Re: Professional Engineer's Certification of Permanent Control Measure
Flying Horse North Filing No. 4, Pond C

This letter serves as a Pond Certification for the constructed Full Spectrum Detention Facility "Pond C" located in Flying Horse North Filing No. 4. The permanent control measure is located at the central east area of the subdivision, adjacent and north of Old Stagecoach Road, east of Fringe Place and west of Rubble Drive.

SHEET
PND

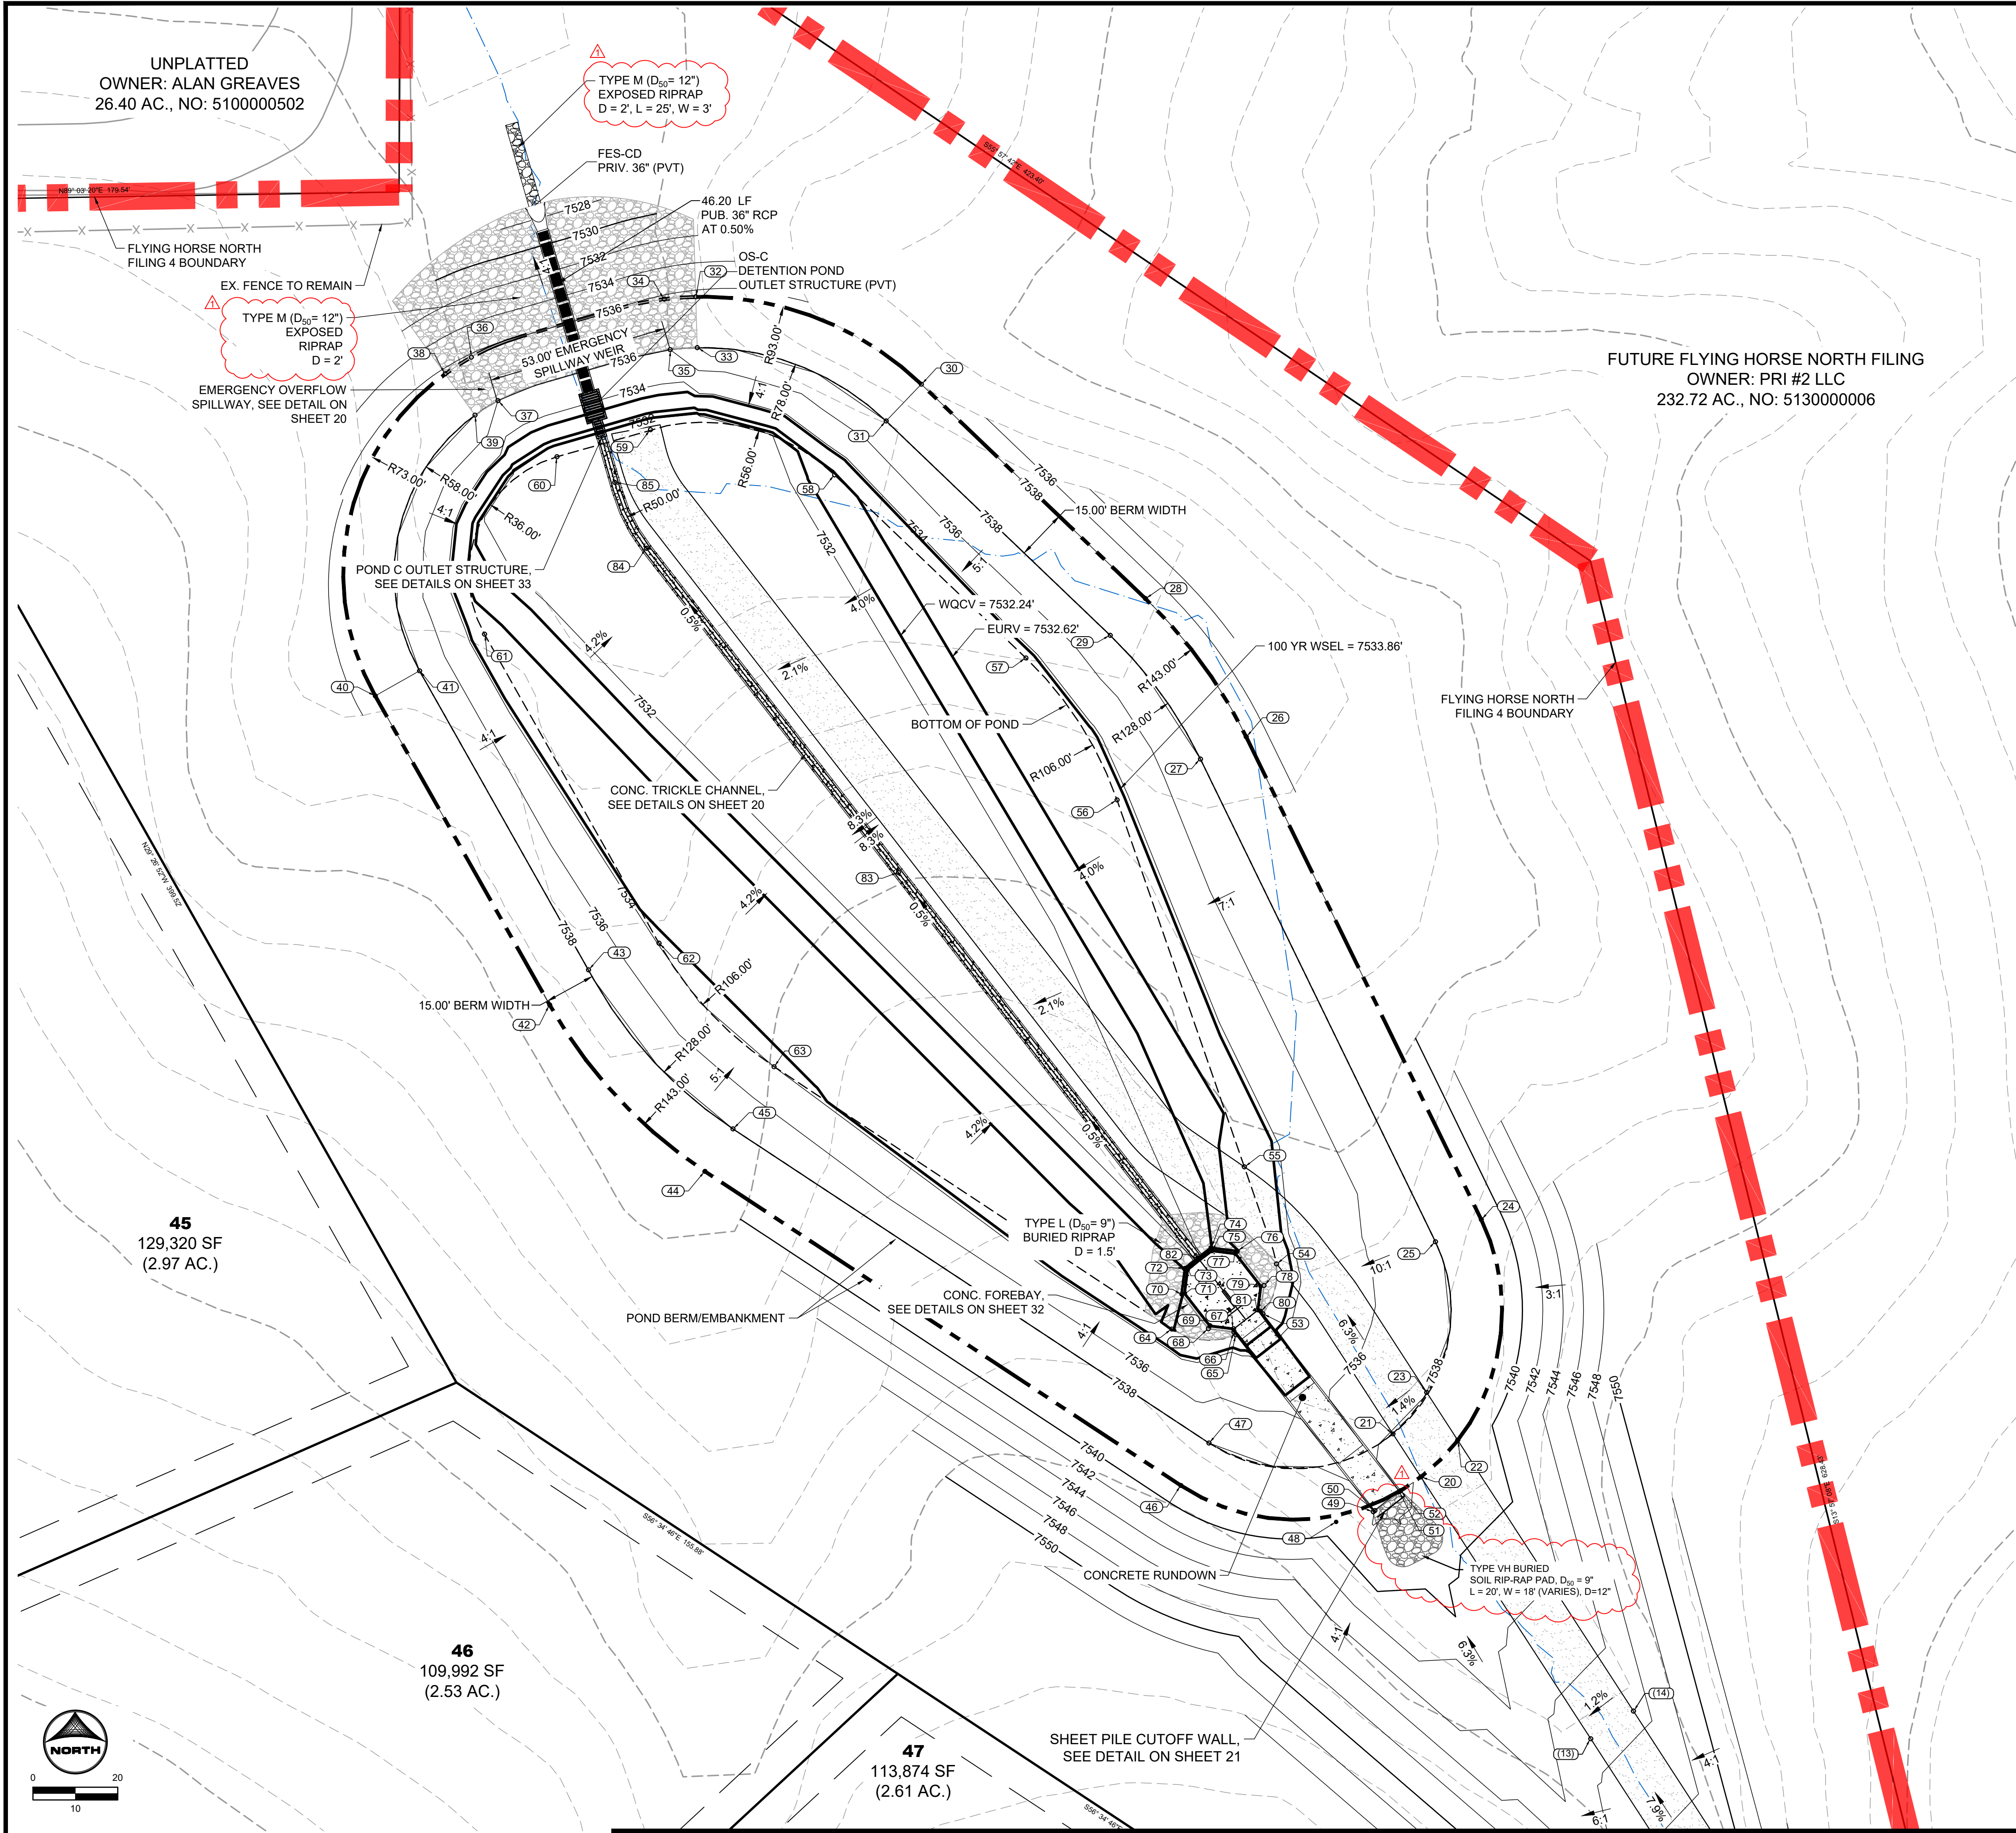
- Outfall Riprap
 - Riprap at the pond outfall is not installed per the approved plans. Plans show buried riprap and in the field it is installed as exposed riprap. Install per approved plans or consult the Engineer of Record. See Note 1. **Outfall/spillway rip-rap is exposed rip-rap and is now reflected on**

- ***the as-builts, as approved by the Engineer of Record.***
 - Also, the riprap apron is not shaped to convey flows. It is piled up such that there is no positive drainage and flows will just bypass the riprap and cause erosion. So please reconfigure riprap to properly convey flows. ***A more defined conveyance V-shape swale has been constructed.***
- Maintenance access road installed with crushed concrete, which per direction from CDPHE is not an acceptable means of Final Stabilization, nor was that material on the approved plans, so please remove and install access road material per plans. ***As-built plans and redlines now call out crushed concrete as approved by the Engineer of Record. This was discussed with Stormwater staff in July 2026 and is to be allowable for this filing.***
